Rezoning Transportation Analysis

Petition Number: 2023-169

Date	Description
01-24-24	First Review (ME)
02-21-24	Second Review (ME)

**SHEET**  
**REZONING PLAN**  
**RZ.01**

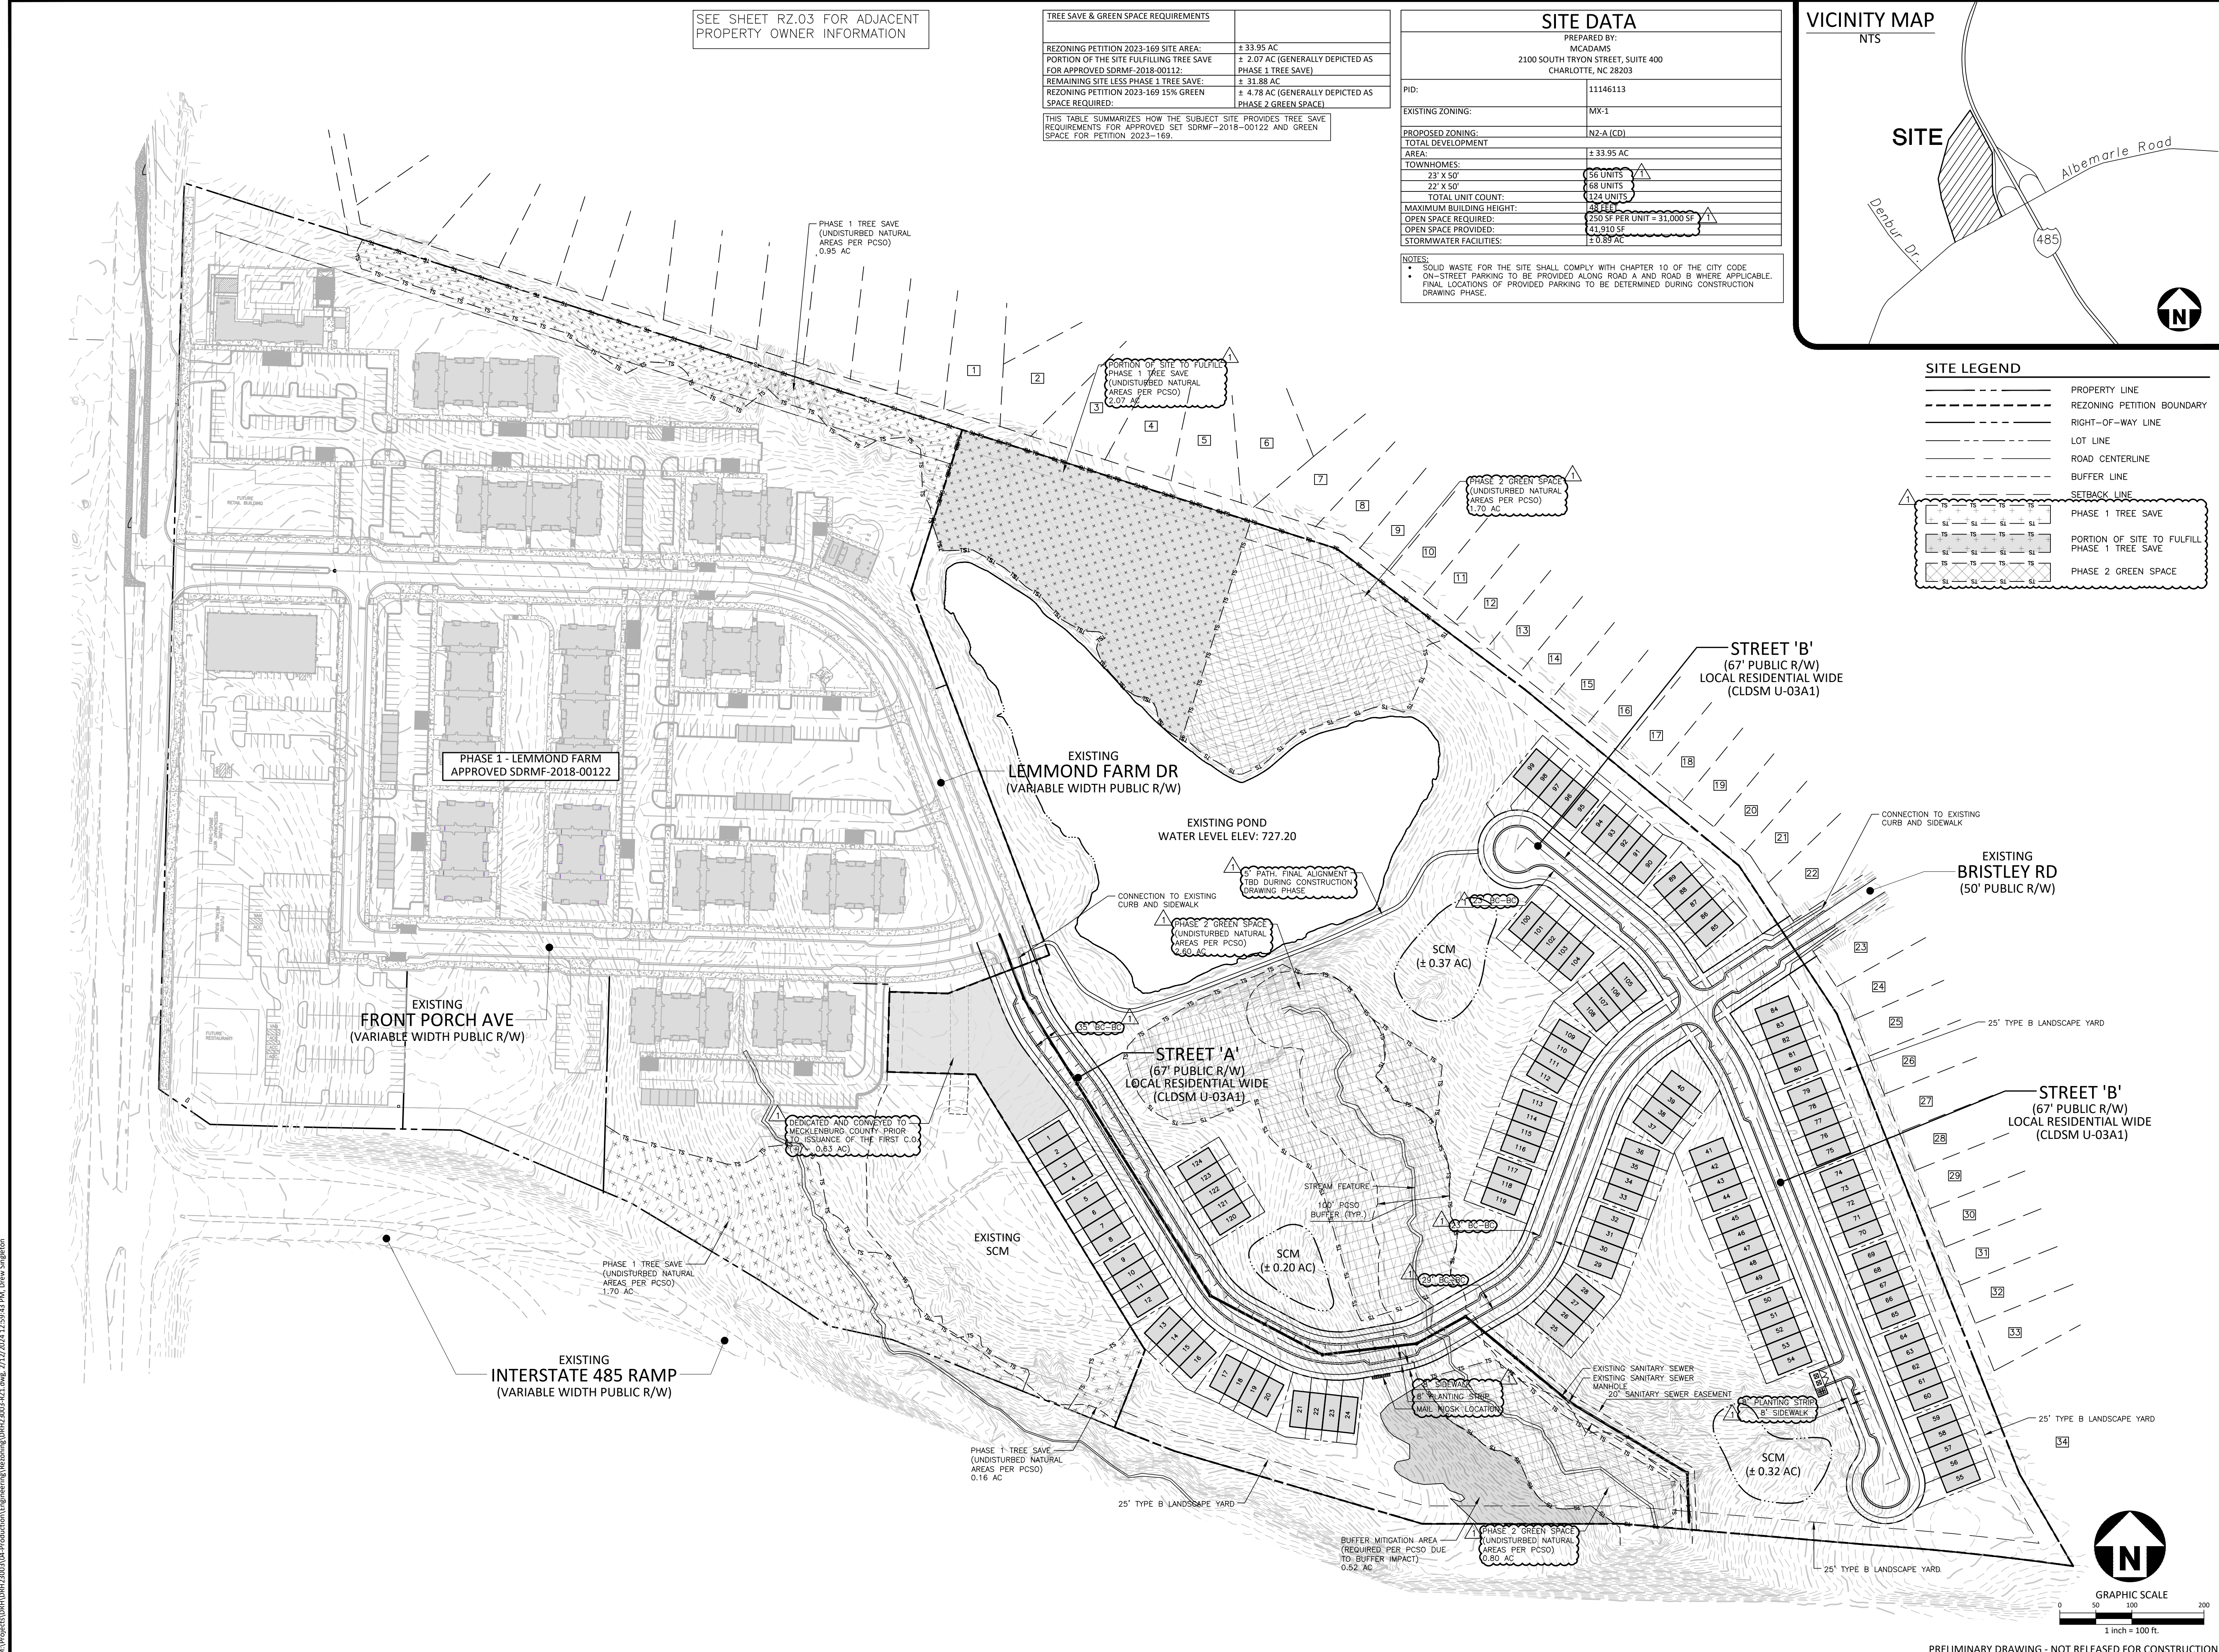
1. ~~Curblines:~~

- a. ~~**Street A:** Location of curb and gutter to be installed to 17.5 feet from roadway centerline to accommodate the CLDSM Detail U-03.~~
- b. ~~**Street B:** Location of curb and gutter to be installed to 17.5 feet from roadway centerline to accommodate the CLDSM Detail U-03.~~

~~Label and dimension the curb and gutter from the centerline for each road on the site plan.~~

- ~~3. Revise site plan and conditional note(s) to commit to dedicate 25.5 ft right of way from the road centerline for Street A and Street B. The site plan shall label and dimension the right of way from the road centerline.~~

- ~~5. Revise site plan and conditional note(s) to commit to construct an 8-foot planting strip, and 8-foot sidewalk on Street A per CLDSM U-03. The site plan shall label and dimension both items from the back of curb and gutter or edge of pavement.~~

- ~~6. Revise site plan and conditional note(s) to commit to construct an 8-foot planting strip, and 8-foot sidewalk on Street B per CLDSM U-03. The site plan shall label and dimension both items from the back of curb and gutter or edge of pavement.~~

- ~~7. Revise site plan and conditional note(s) to commit to alley loaded driveways on Street A where possible.~~
 - ~~8. Add a conditional note specifying "the Petitioner shall dedicate and convey in fee simple all rights-of-way to the City before the site's first building certificate of occupancy is issued. CDOT requests rights-of-way set at 2' behind back of sidewalk where feasible."~~

- ~~11. Revise site plan and conditional note(s) to construct 8-foot planting strips and 8-foot sidewalks on Street A and Street B. The site plan shall label and dimension both items from the back of curb and gutter or edge of pavement. Add conditional note The entire facility must be outside of the right of way and within a public access easement. Add conditional note committing to construction and maintenance of the 8-foot sidewalks on Street A and Street B.~~

REZONING PLAN
RZ.01

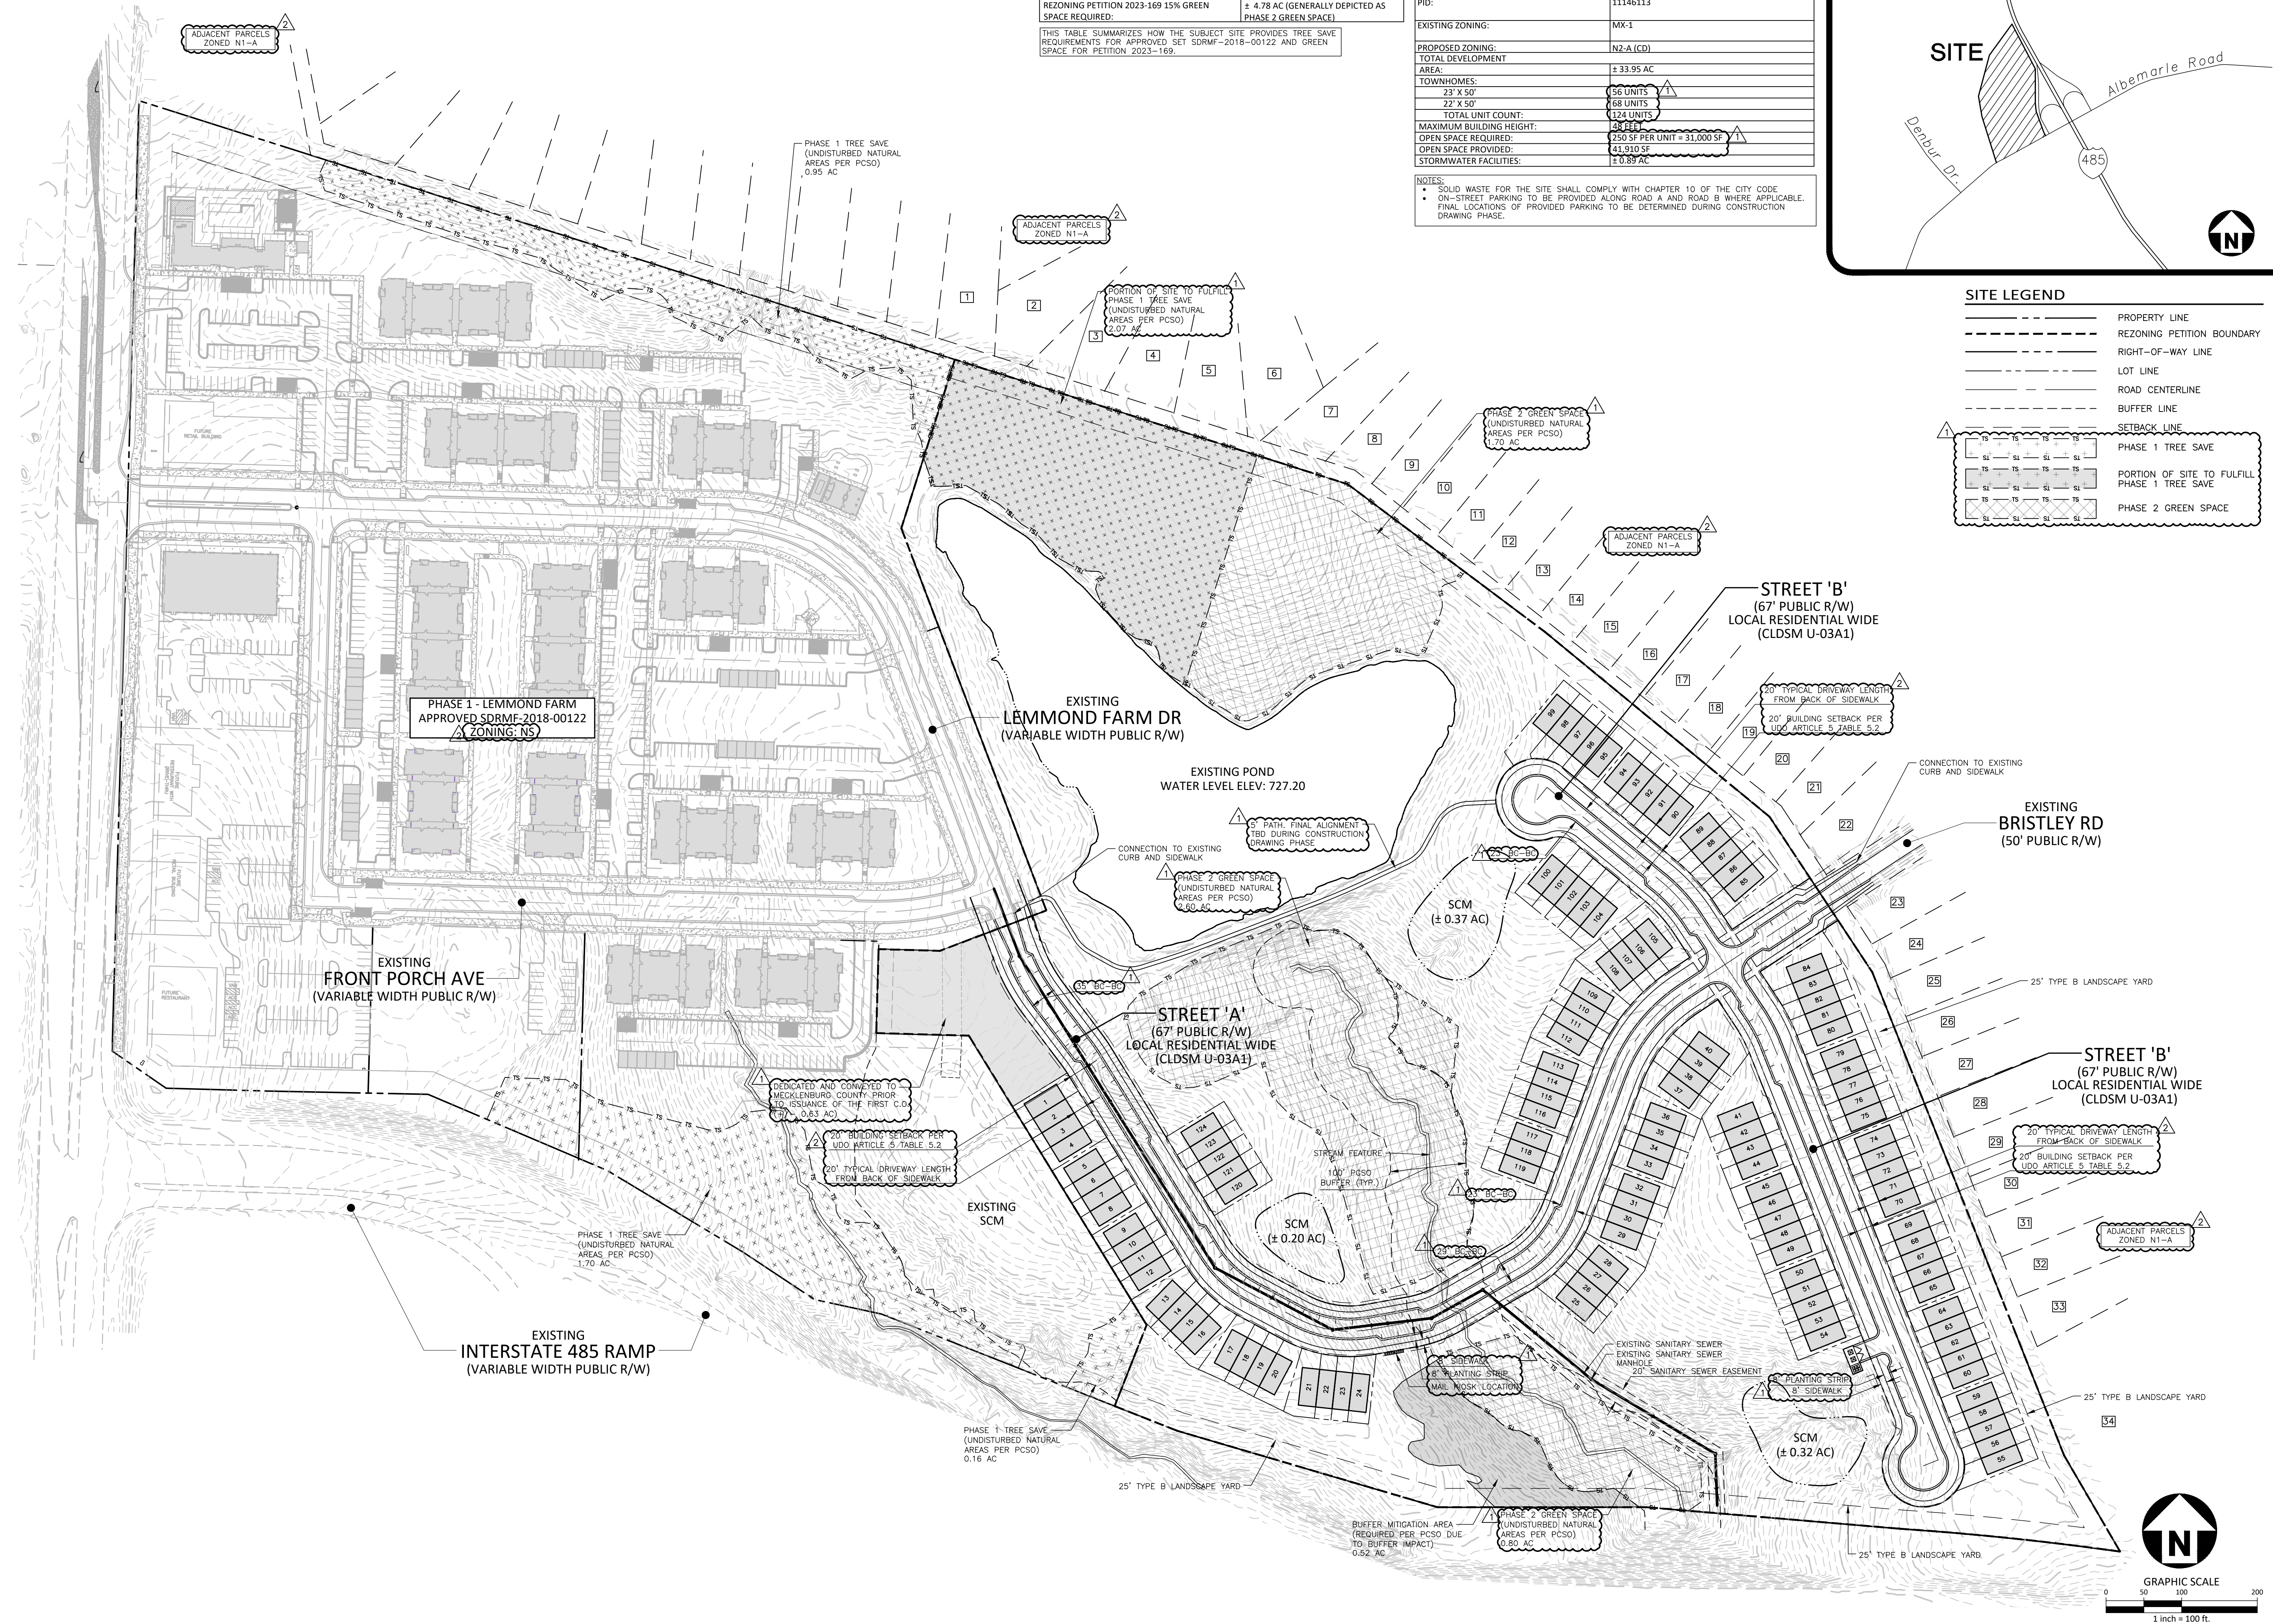
The petition's zoning falls within the low intensity development which based on the 826 daily trips will trigger Tier 1 (3 mitigation points) for multimodal assessment. The petitioner shall review and assess the publicly accessible pedestrian network within ¼ mile walking distance of the site to identify multimodal infrastructure to meet the Tier 1 (3 mitigation points) for multimodal assessment.

Clarifying comment 02.21.24: Proposed mitigation will satisfy CTR but complete CTR summary table and include on the revised plan. CTR table link (use Site Data Table – CTR Summary tab): <https://www.charlottenc.gov/files/sharedassets/city/v2/growth-and-development/documents/dev-center-fees/resources/udo-site-data-tables-curb-ramps-and-ctr.xlsx>
